LOCAL HIGHWAY AUTHORITY CONSULTATION

Planning Application No	12/01787/REM	Planning Officer	Linda Griffiths
OCC ref No	n/a	OCC Officer	Michael Deadman
Date	13/03/12	Comments	Conditions

Location: KM7 & KM9 South West Bicester Development Site, Middleton Stoney Road, Bicester, Oxfordshire.

Description: Reserved Matters (Outline Application 06/00967/OUT) - Appearance, landscaping, scale and access comprising residential development for 141 no. dwellings.

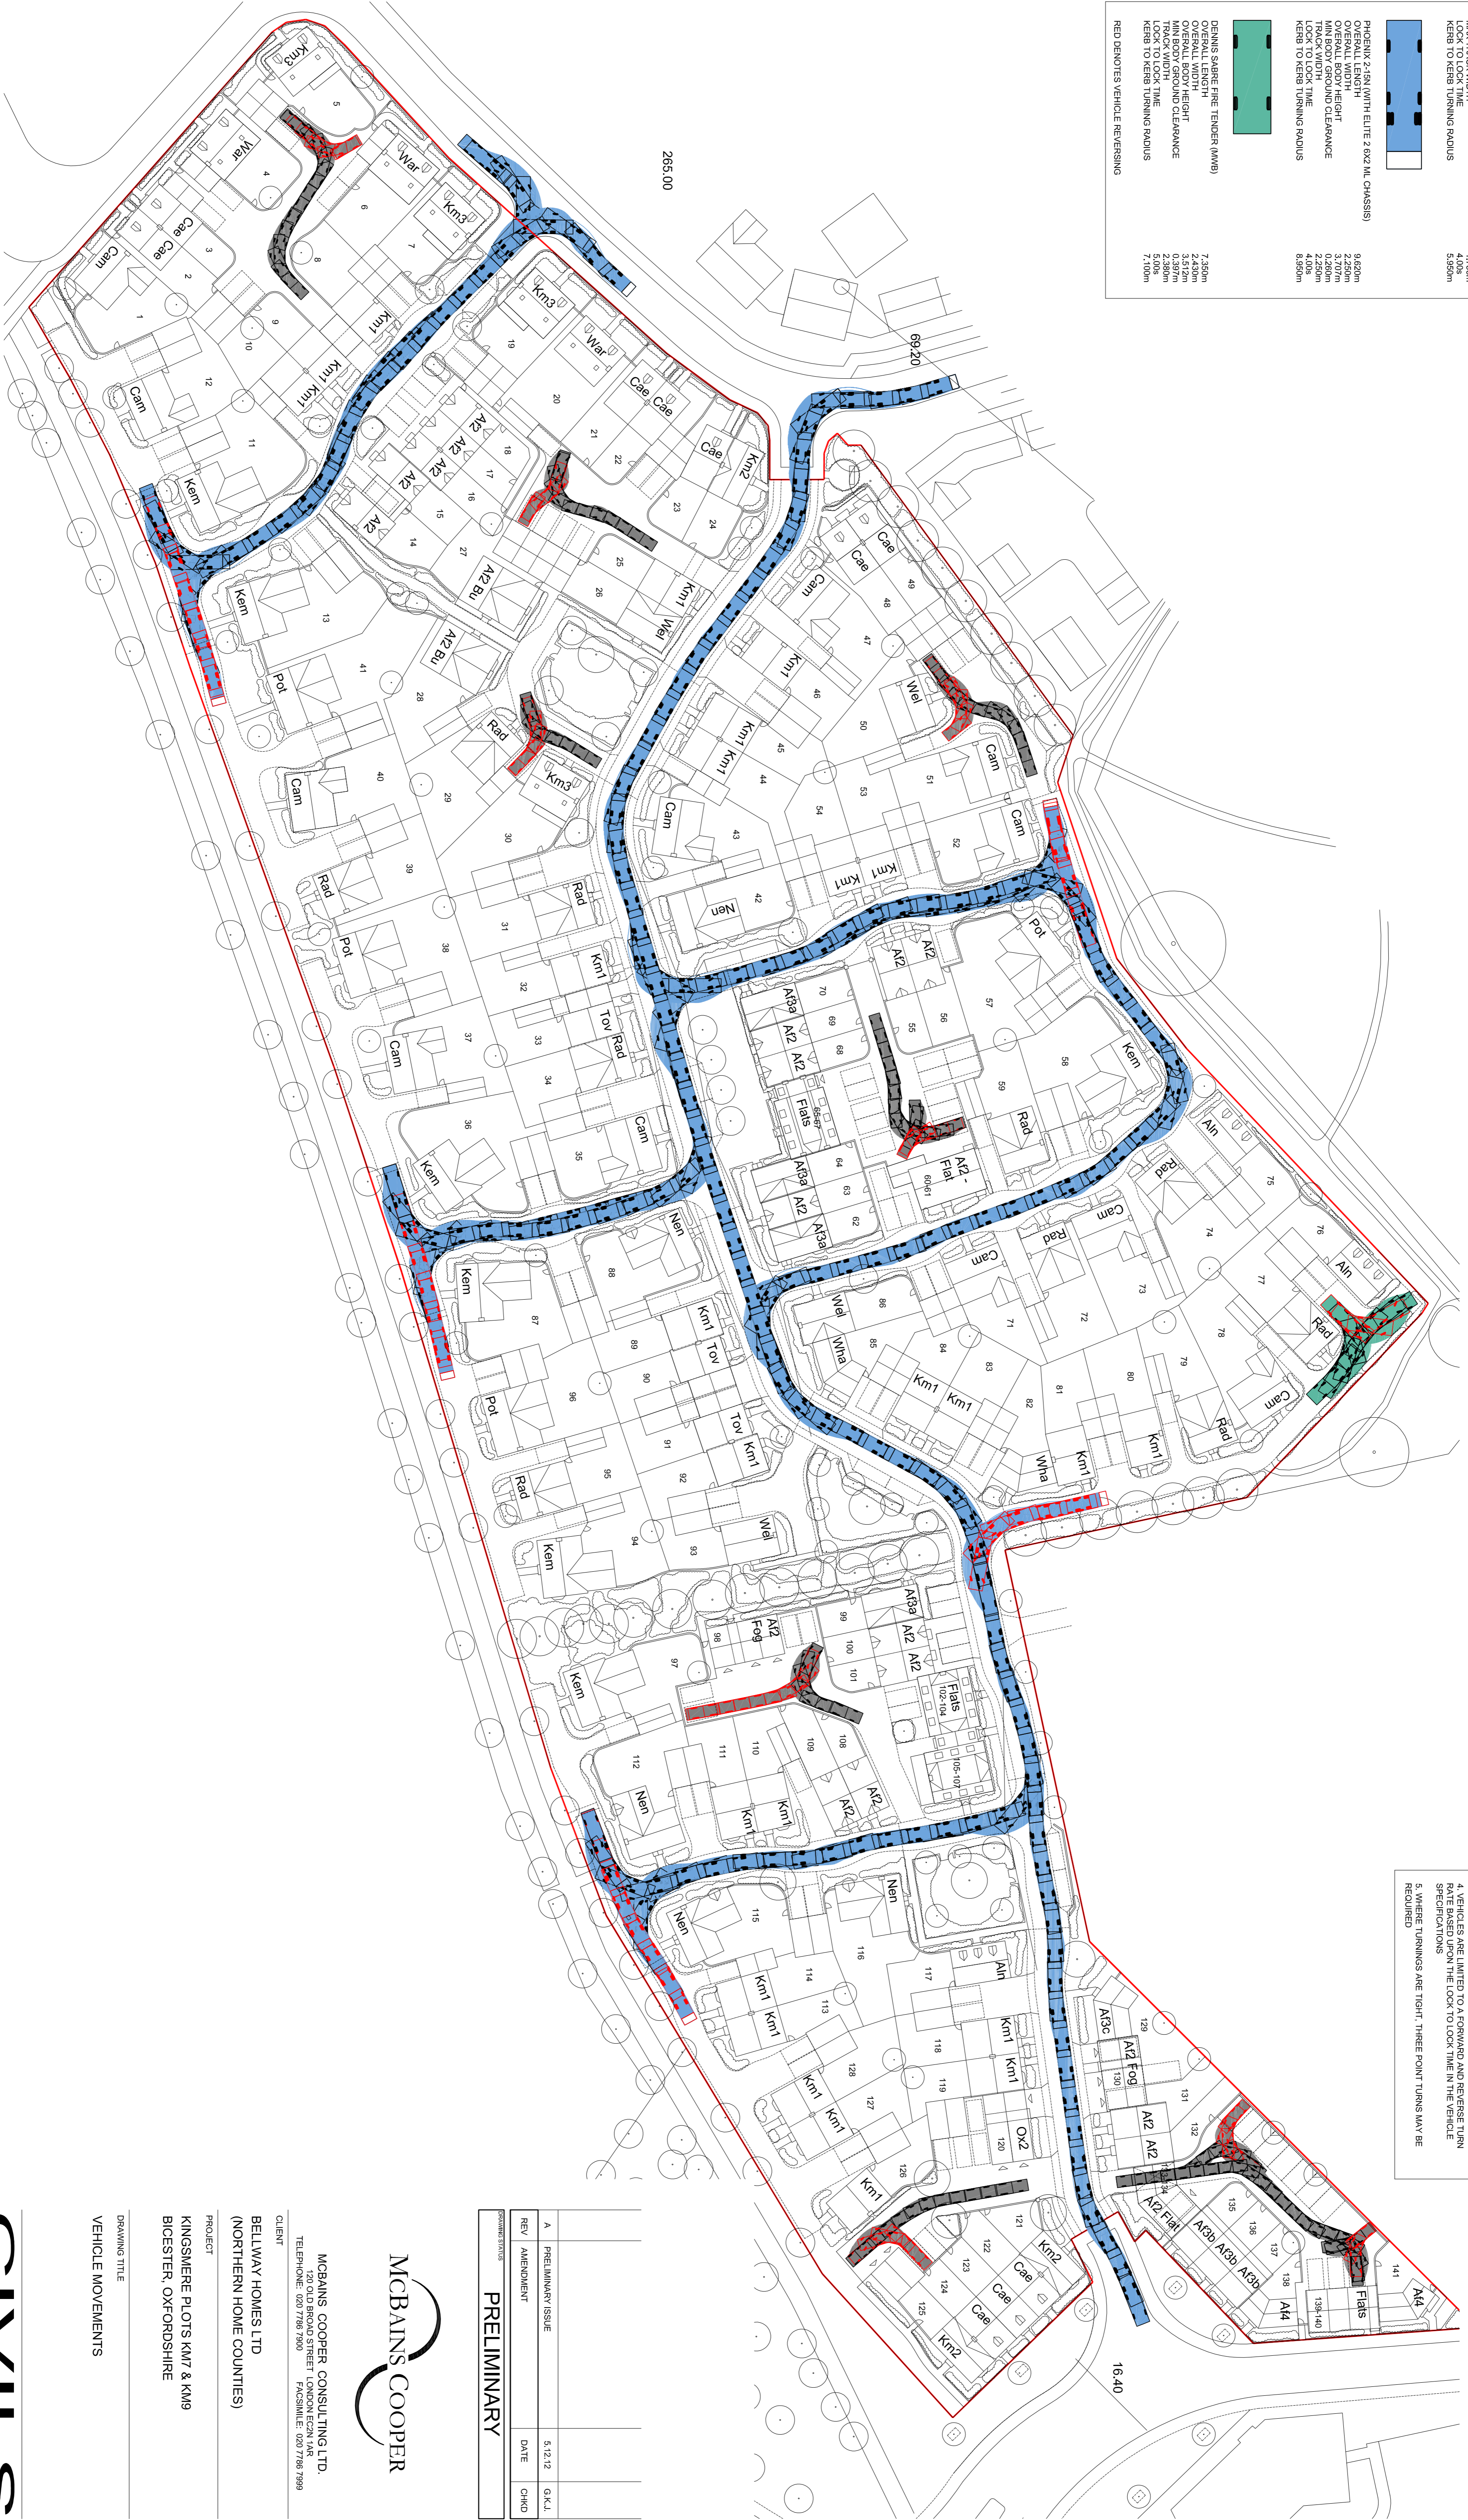
HGV Tracking plan – the tracking plans submitted (LCS_56234_610/A & AR56234-103)) appear acceptable, although in some areas it is acknowledge some of the tracking movements are tight. Type of vehicles tracked are acceptable, the largest being 9.620m in length.

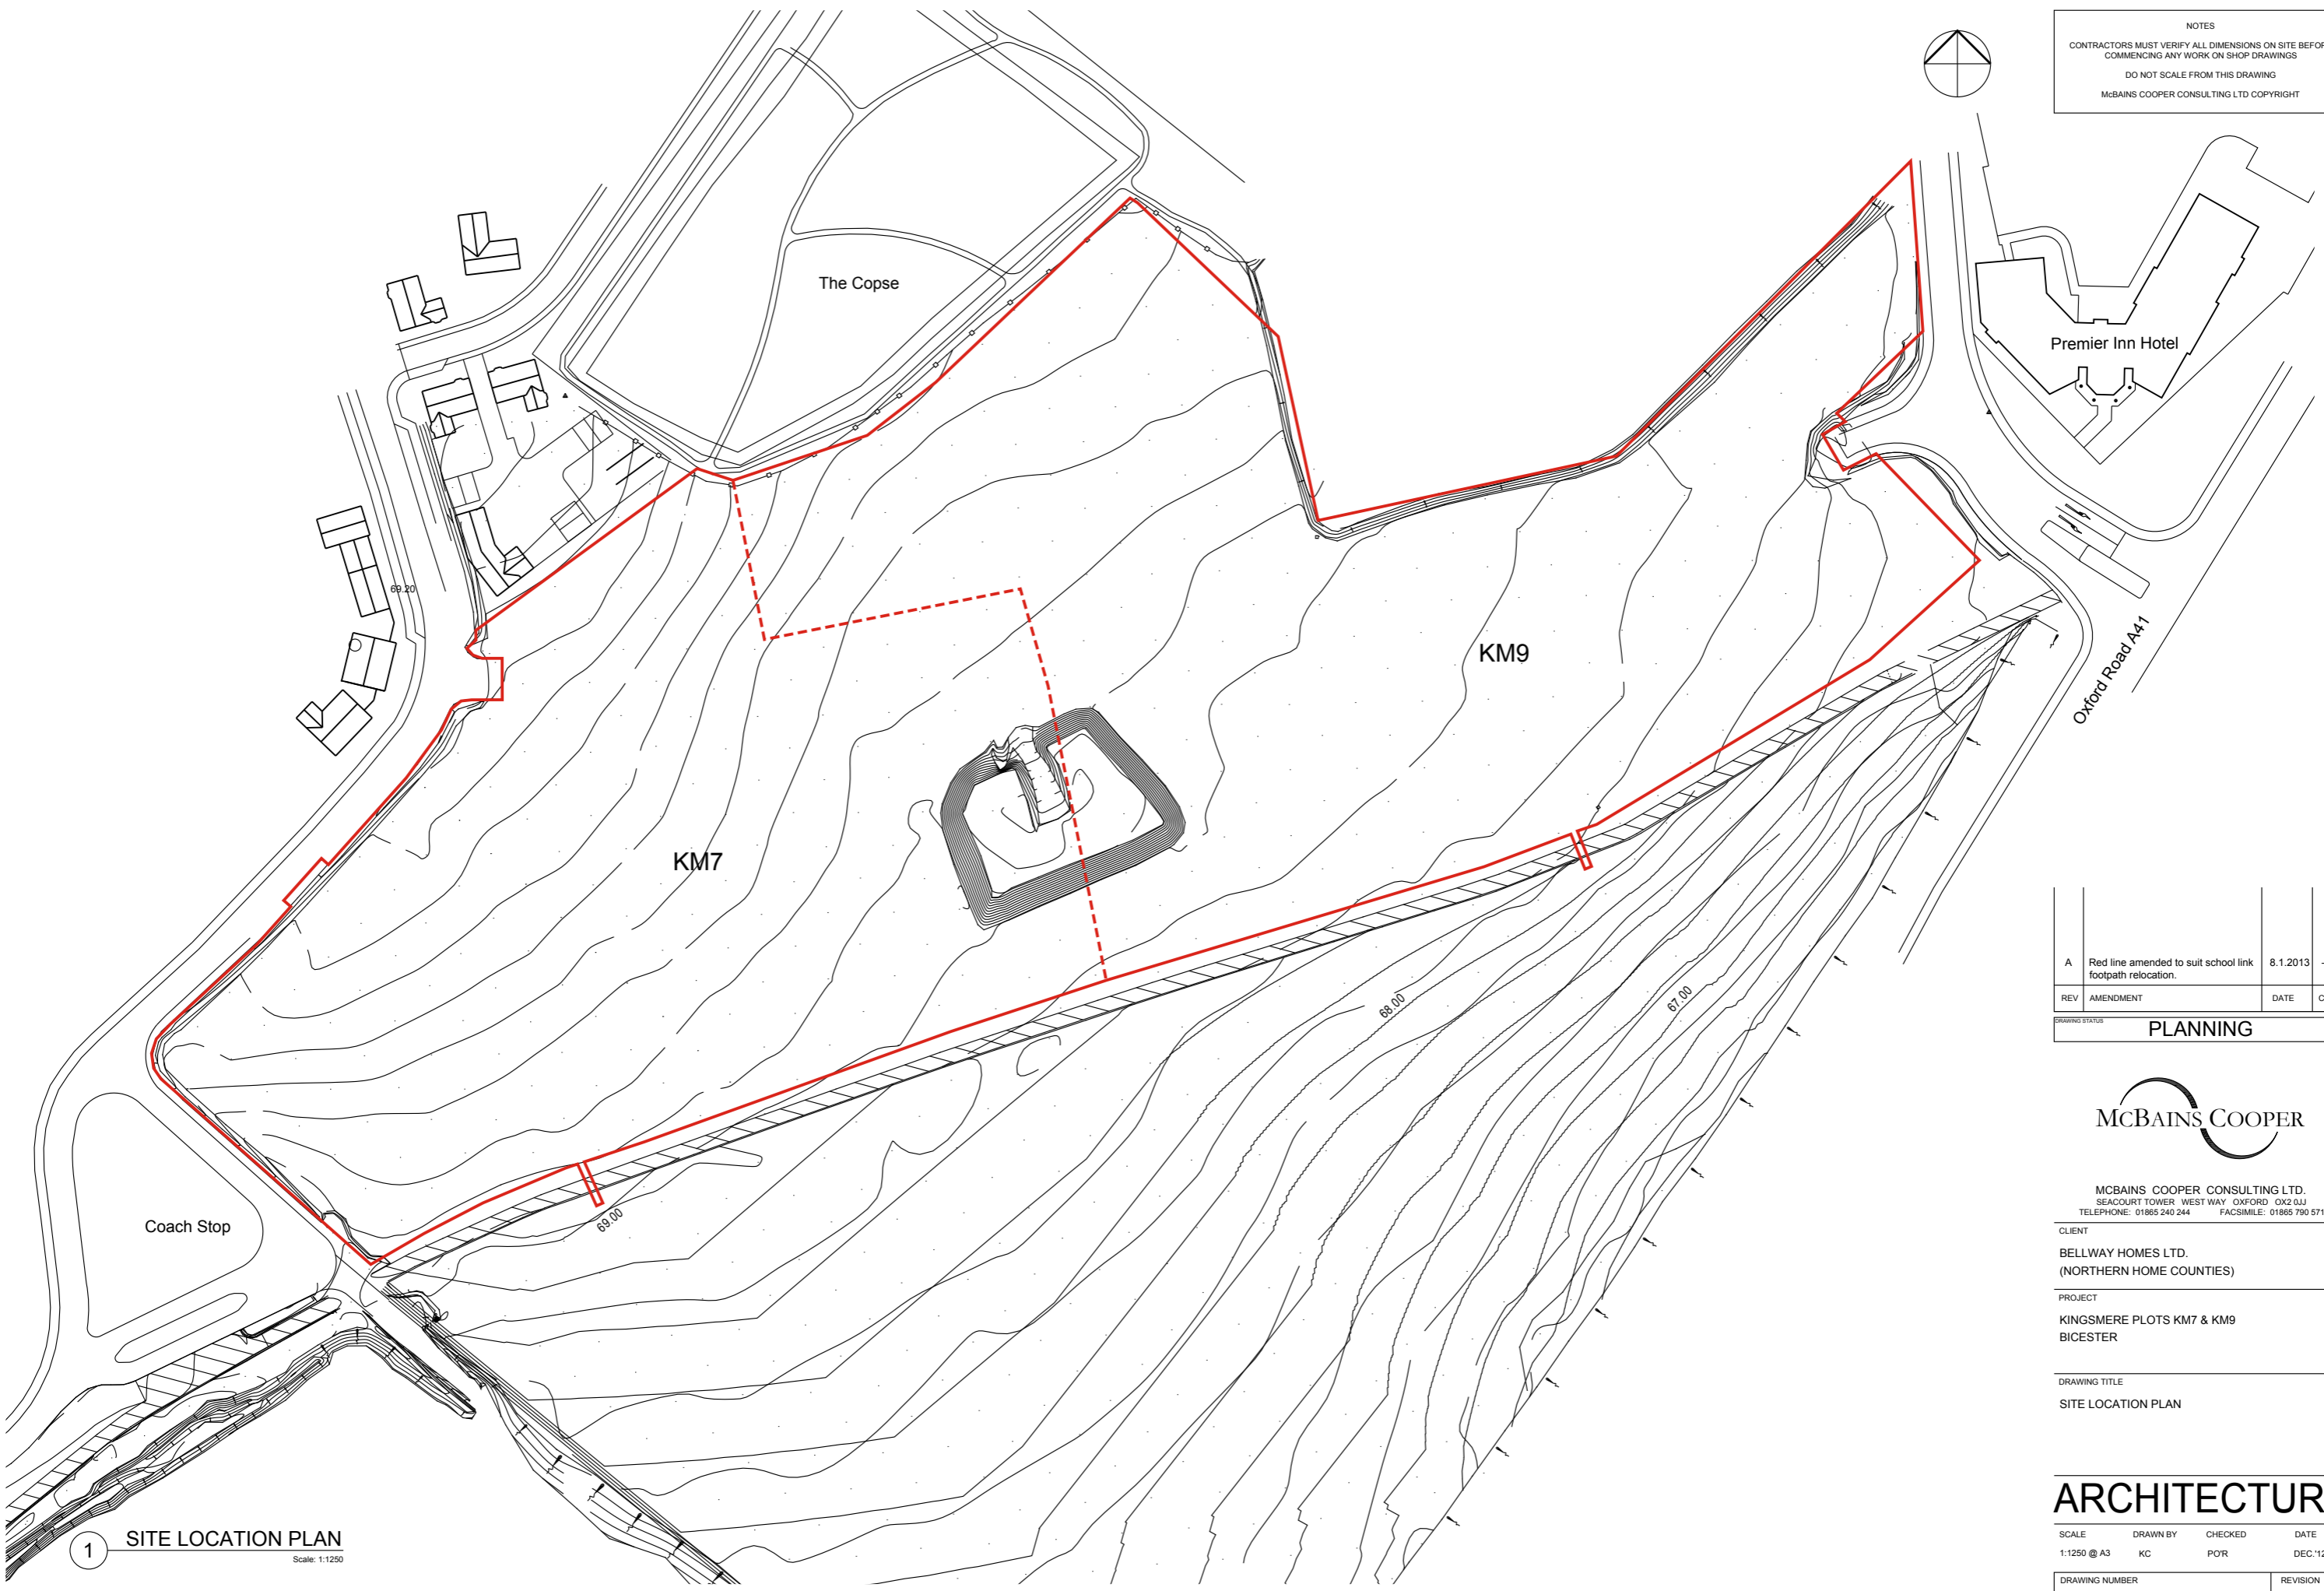
- *Due to the potential through traffic from the A41 junction nearby there are a number of areas shown/proposed to be traffic calming features on the submitted site layout plan (AR56234-101). The desired option for such calming features are physical narrowing's of 3.5m along the Side Street in the areas indicated on the layout plan;*

4. Before any of the dwellings are first occupied in Phase KM7 & KM9 the parking and manoeuvring areas shall be provided in accordance with the plan (*AR56234-101*) hereby approved and shall be constructed, laid out, surfaced, drained and completed, and shall be retained unobstructed except for the parking and manoeuvring of vehicles at all times.
